**RE: Lot 2 Block 2 Unit 22 Volcano Cliffs SAD 228
8020 Canoncito Dr. NW
Grading and Drainage Plan
Engineers Stamp Date 2/13/17 (D10D003C2)**

RE: Grading plan resubmittal (D10D0003C2)
8020 Canoncito NW

**RE: Lot 2 Block 2 Unit 22 Volcano Cliffs
8020 Canoncito Dr. NW (S.A.D. 228)
Grading and Drainage Plan
Engineers Stamp Date 2/2/17 (D10D0003C2)**

ENGINEER'S SEAL  2/2/17 DAVID SOULE P.E. #14522	LOZOYA RESIDENCE 8020 CANONCITO DR NW GRADING AND DRAINAGE PLAN  <i>Rio Grande Engineering</i> 1606 CENTRAL AVENUE SE SUITE 201 ALBUQUERQUE, NM 87106 (505) 872-0999	DRAWN BY: WCWJ DATE: 2-02-17 21706-LAYOUT-2-01-17 SHEET # JOB # 21706

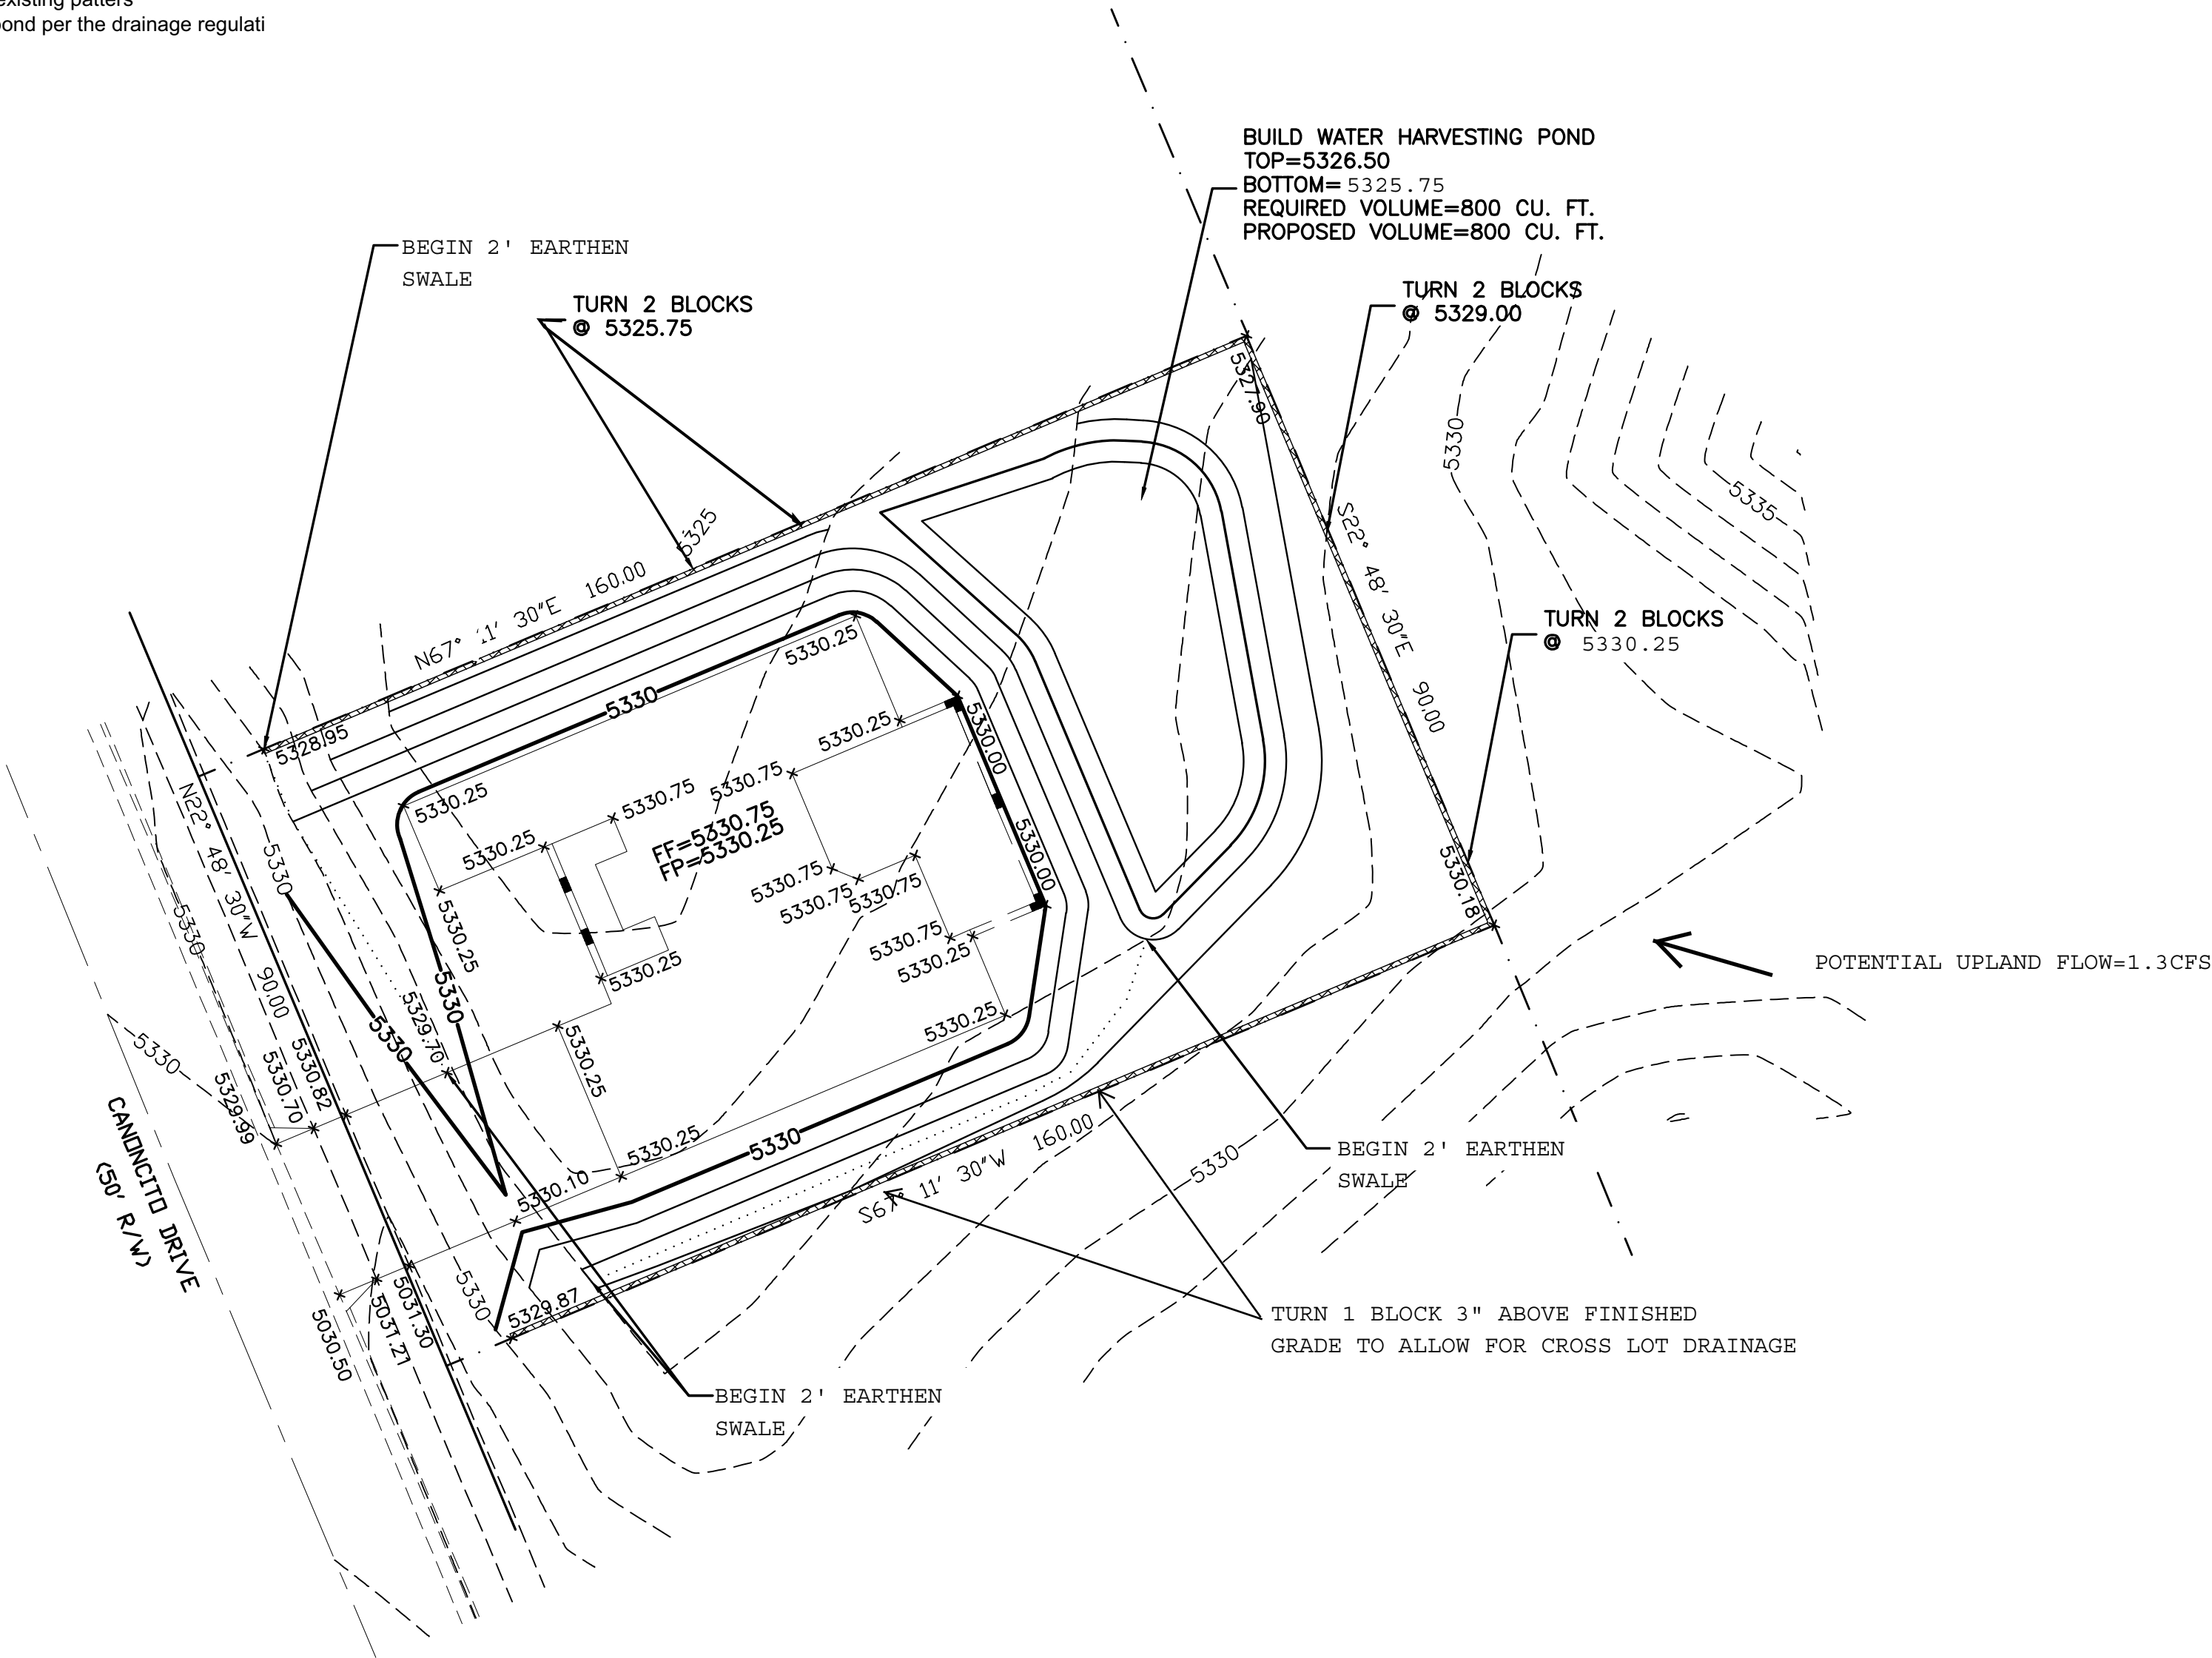
- The turn blocks are located wrong, the turn blocks should be located in the 10' PUE, which will allow flows to pass through the rear yard, accepting flows from the north heading south, eventually entering Kimmick Road.
- Show the 10' PUE in the rear yard. Provide a swale in the PUE, 1 foot away from the block wall.
- Along with the 3" above grade statement, place the height of the block as a spot elevation.
- Provide a statement that a pad certification is required before a Building Permit is released.
- Provide a statement that the block fence requires a separate permit and the approved grading plan must be provided with the plan set and permit.

ENGINEER'S SEAL 2/13/17	LOZOYA RESIDENCE 8020 CANONCITO DR NW	DRAWN BY: WCVJ DATE: 2-02-17
	GRADING AND DRAINAGE PLAN	21706-LAYOUT-2-01-17
 1606 CENTRAL AVENUE SE SUITE 201 ALBUQUERQUE, NM 87106 (505) 872-0999		SHEET # —
		JOB # 21706

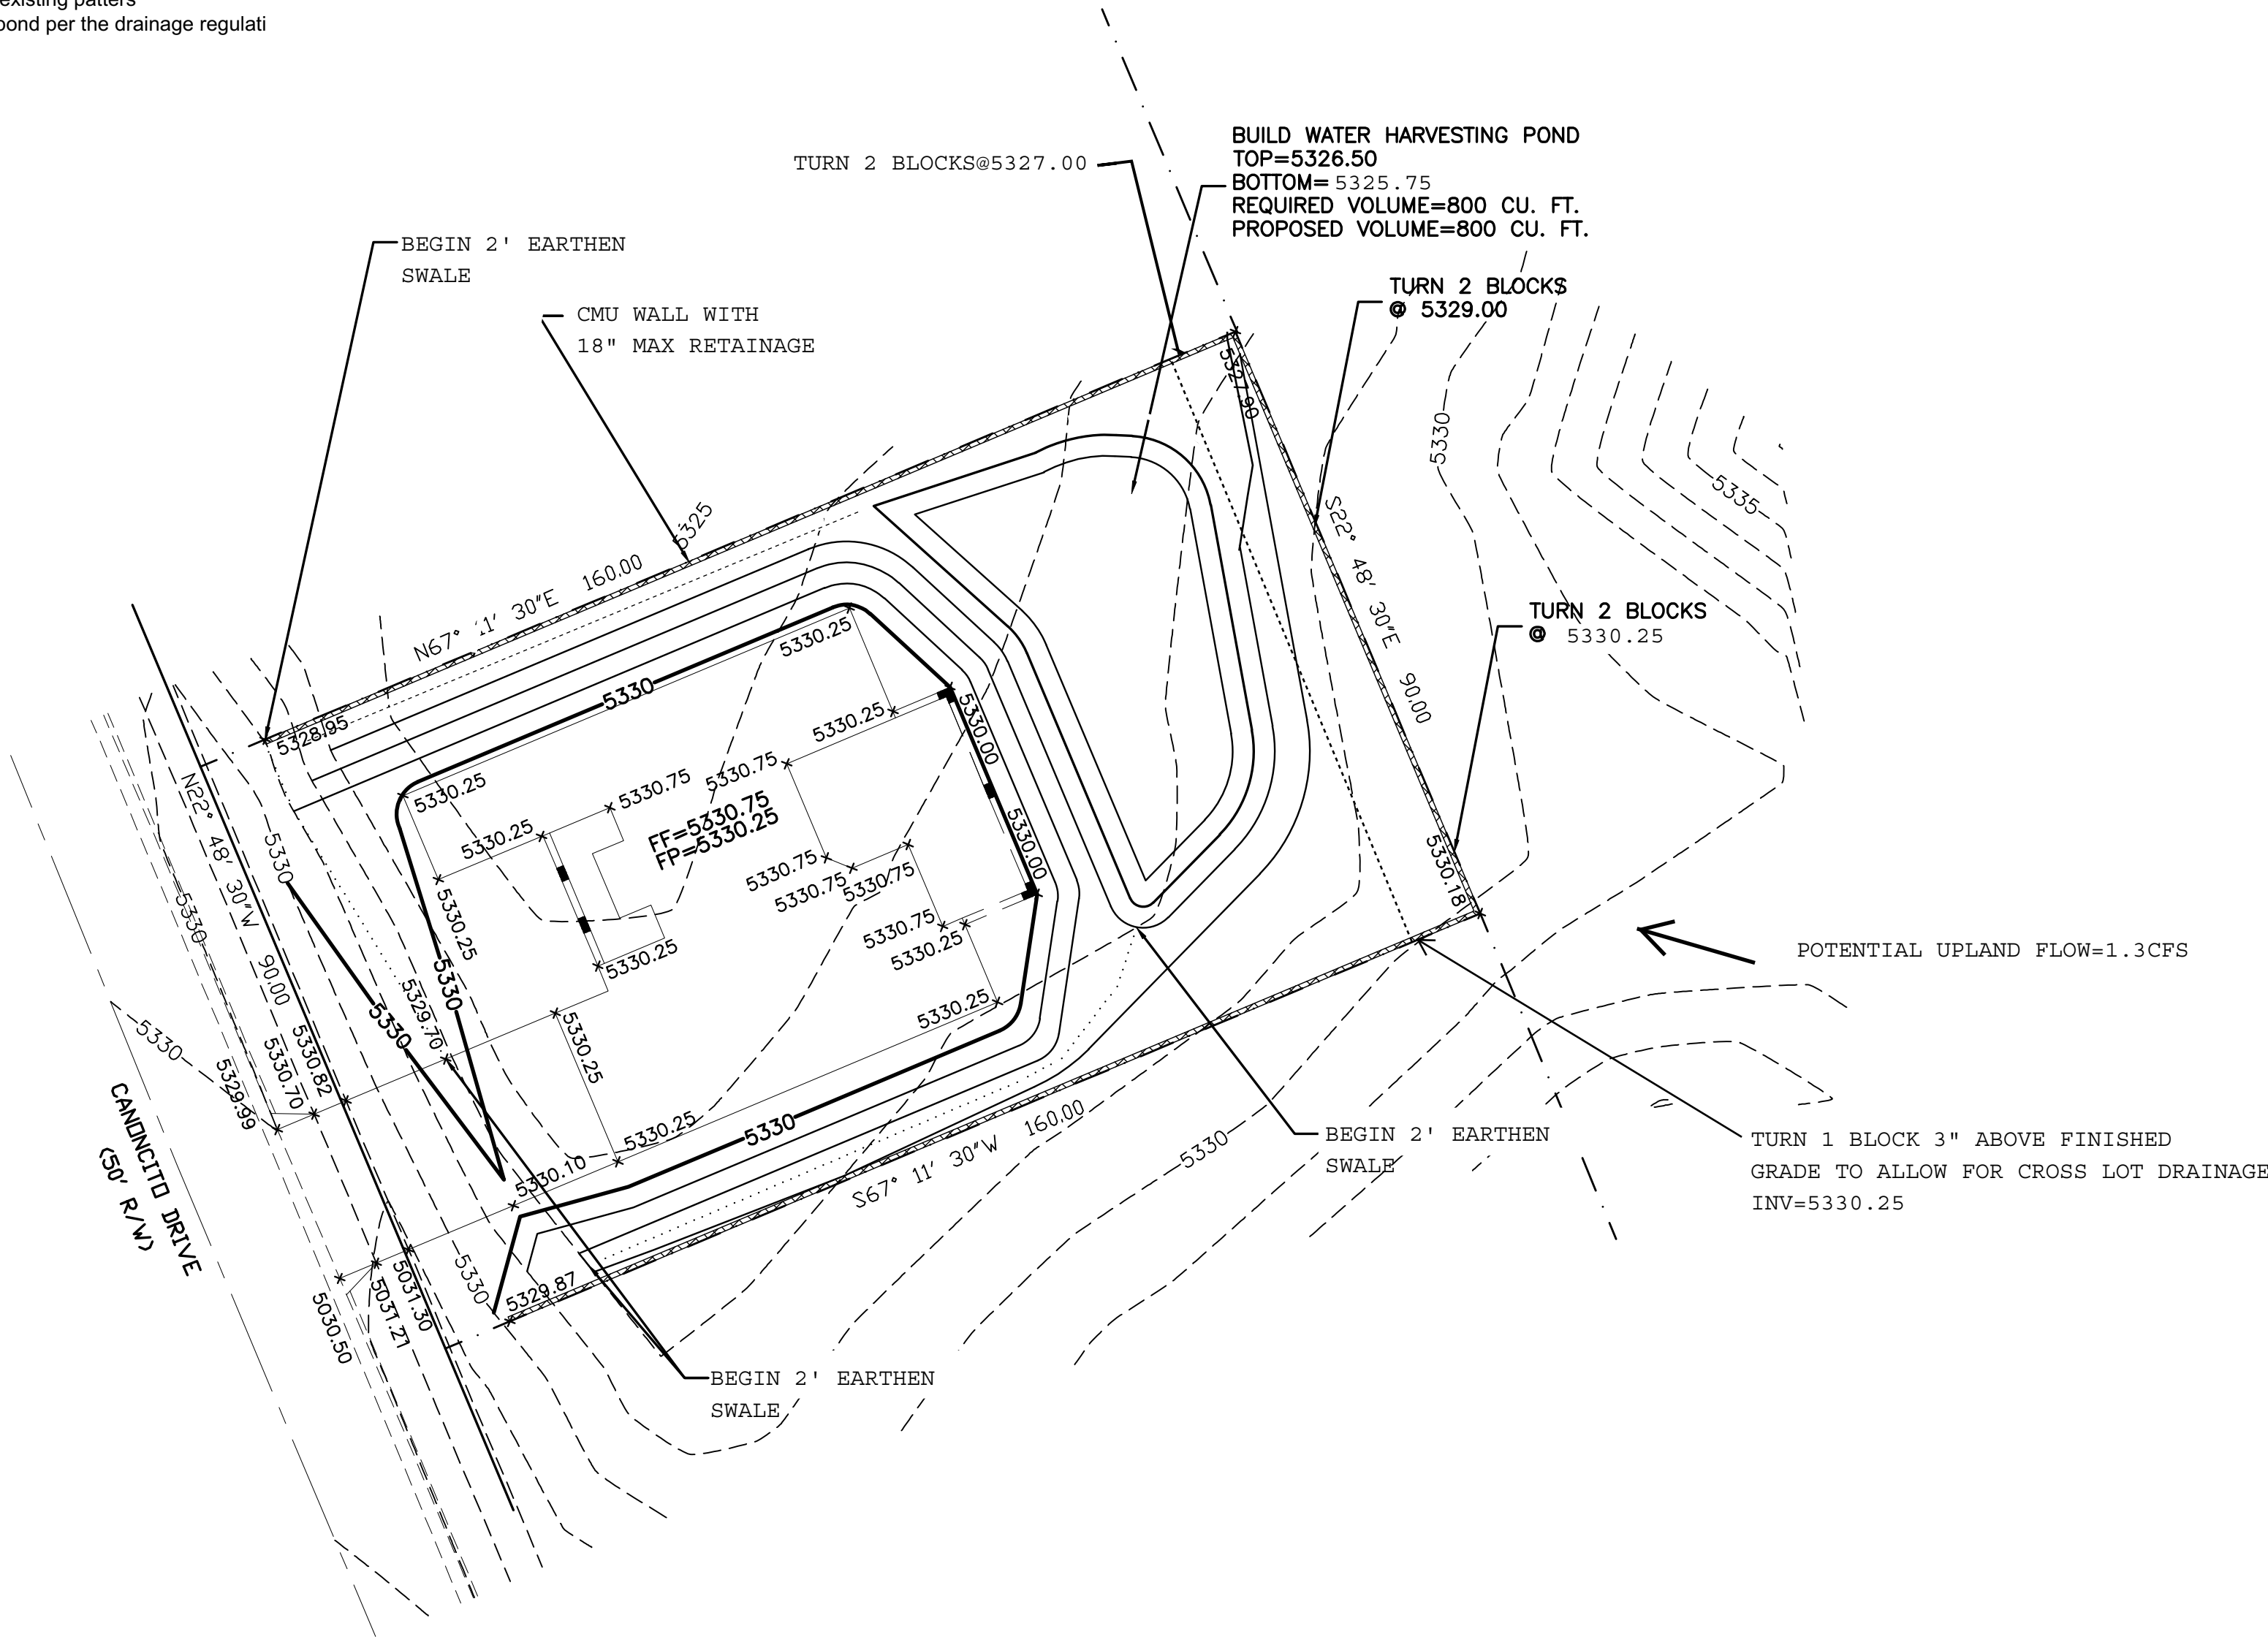
1. Place turned blocks within the rear 10' PUE

2. Show 10' PUE and place swale 1' away from wall

3. Place elevation at turned blocks

4. Provide statement regarding pad certification

5. Provide statement regarding block wall construction.

We have moved the blocks.

The existing grades do not lend themselves to place swale at the requested location.

We have forced the entry and exit point to that location but to place swale will required too much fill. The water will enter and leave at the prescribed locations

We have added

This has been added as note #4

This was described in note #3
